From: [Sargeant House](#)
To: [Zach Torrance-Smith](#); [Sargeant House](#)
Subject: Reasonable Use Exception Request - Pazaruski - parcel 558535
Date: Thursday, April 23, 2026 10:17:18 PM

This email is in regard to the Notice of Application received regarding the Pazaruski Reasonable Use (RU-26-00001) project with parcel number 558535.

LOT 9 HYAK ESTATES 2 GRADING DESIGN
RYAN PAZARUSKI
SITE PLAN

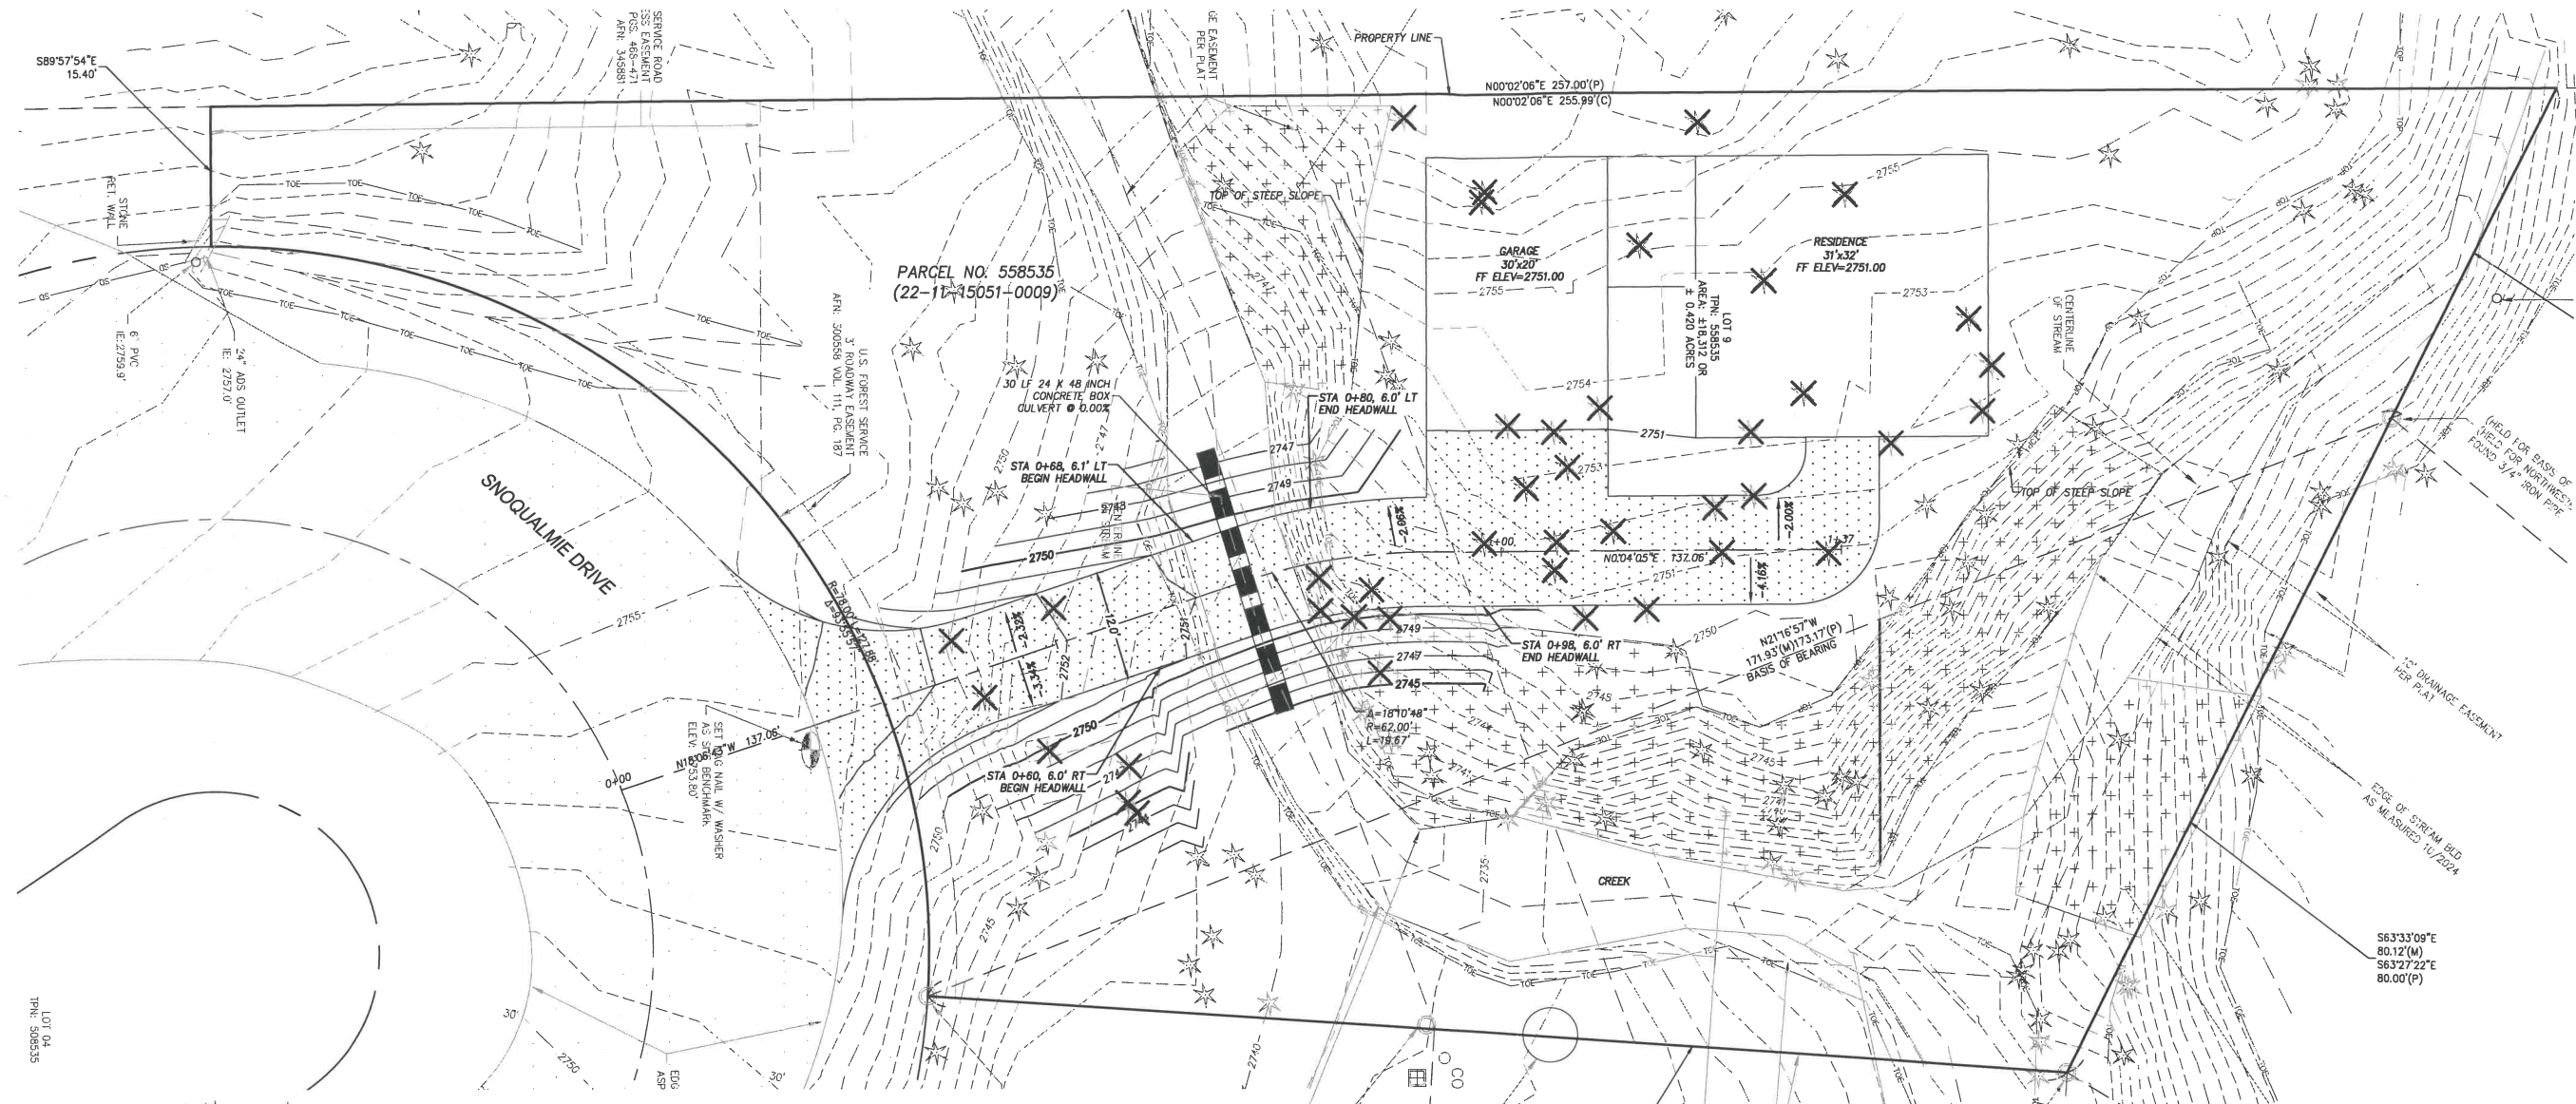
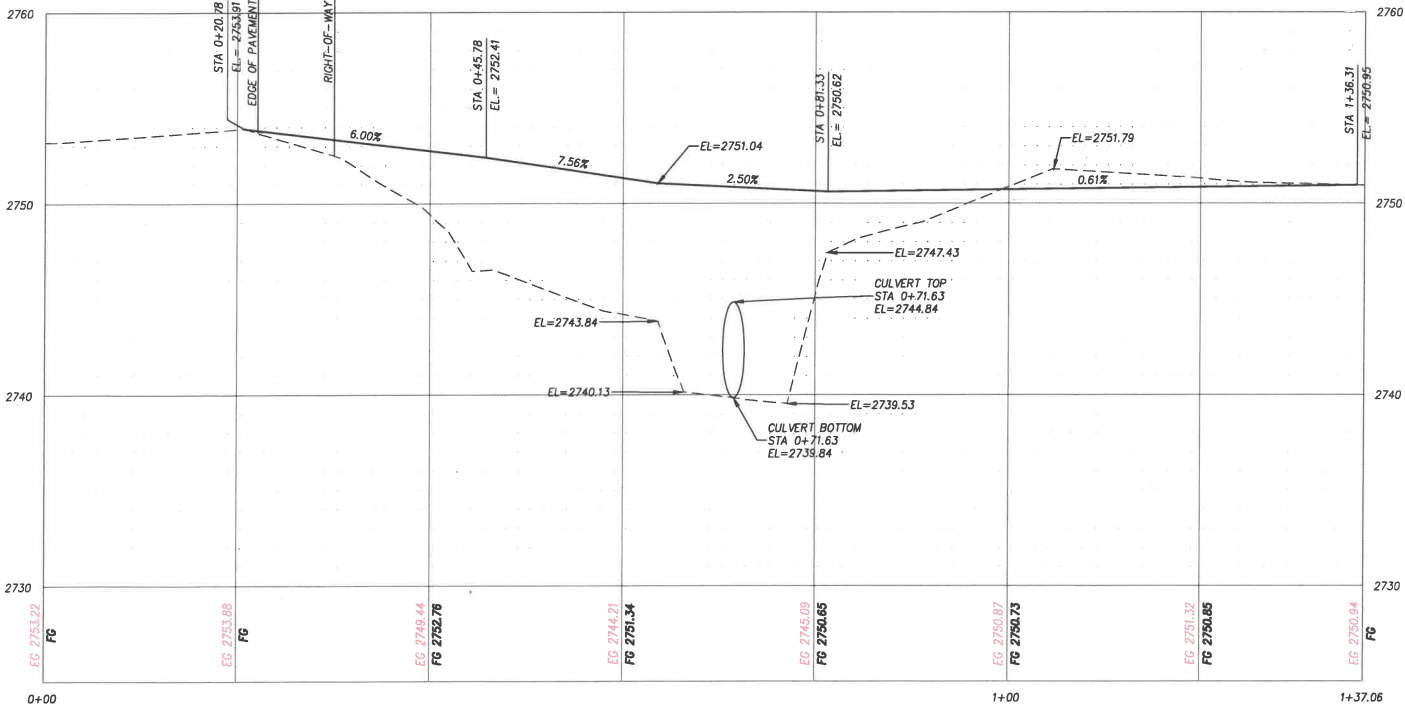
5. Culvert Design - there is insufficient information provided regarding the design of the proposed culverts. In the documents provided to the county and to the Hyak Property Owners Association, there is very little information provided and only so much as to say it will follow other culverts in the neighborhood. This design plan is not enough. The amount of water that flows through the streams on the property during the fall and spring seasons is substantial and even heavier during rain and flooding events like this past year. To simply plan on building something similar to another part of the neighborhood is irresponsible. **These statements are concerning**.

7. Inconsistent Information - the owners have presented inconsistent building plans to the county and to the Hyak Property Owners Association for review. The house and garage sizes are not the same and other details do not align. **This information is inconsistent and misleading**.
